From: Armijo, Ernest M. <earmijo@cabq.gov>
Sent: Tuesday, August 30, 2022 10:33 AM
To: Marc Gonzales
Subject: RE: Bob's Burgers 3 TCL Comments

From: Marc Gonzales
Sent: Tuesday, August 23, 2022 12:03 PM
To: Armijo, Ernest M. <earmijo@cabq.gov>
Subject: Bob's Burgers 3 TCL Comments
Importance: High

10. ADA curb ramps:

11. Chico drivepad:

SHEET TITLE  
Traffic Control  
Layout

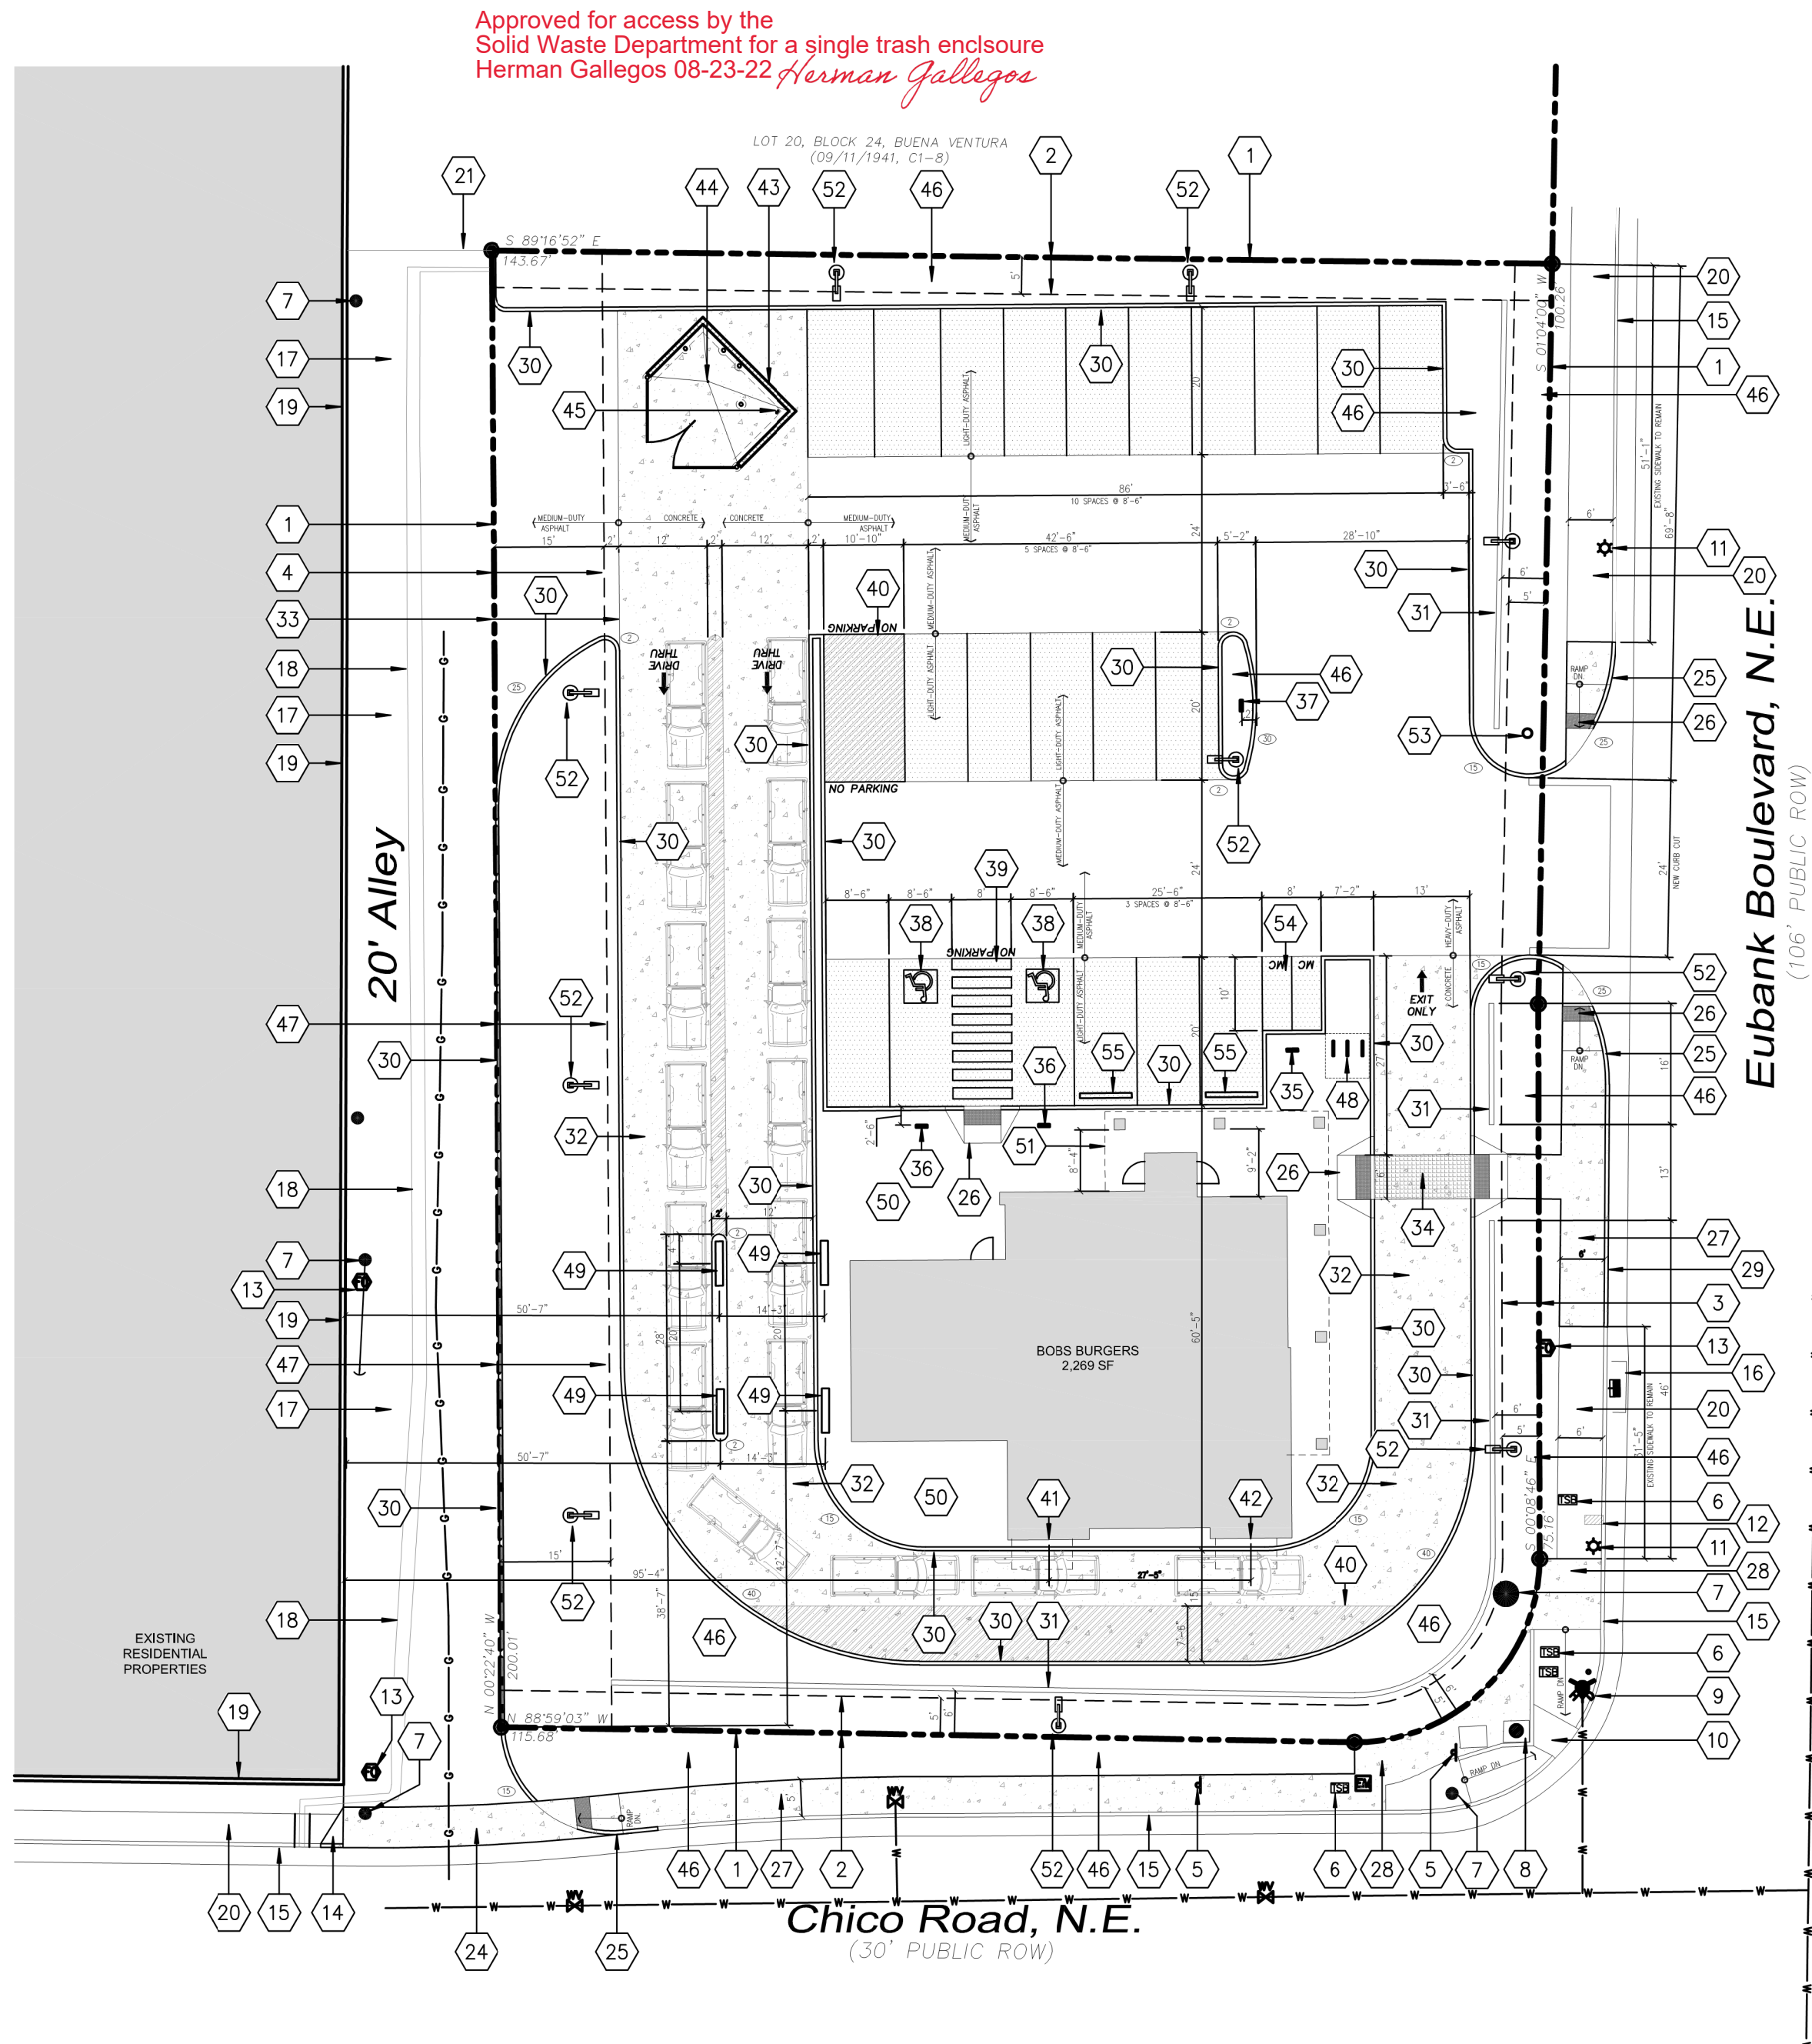
- Eubank/Chico: Corner ramp must be current/updated design and have truncated domes installed for public ramps.
- Must be updated to current standards. And have truncated domes installed for public ramps and details must be provided for each type of proposed ramp.
- Keyed Note 14 & 28: You will need a full detail of ramp to include dimensions and concrete design and slopes.

- Provide details for all proposed infrastructure on plans.
- A special detail will be needed for drivepad transitioning from pad to curb returns (from a gutter pan to a 6' valley gutter).
- Locate proposed sidewalk segment to property line and not at back of curb as shown.
- You will need adjacent property owner permission to perform work on his frontage. Provide letter of permission.
- Call out COA std dwg 2430 for Keyed Note 27.

It was agreed during the site visit on Friday 08.19.2022 the proposed solutions as described within the TCL responses from my office would be acceptable. You mentioned you would put together a written response affirming what we agreed upon to ensure there would not be any hang-ups as we formally responded to TCL. Thank you for your time and consideration in these matters.
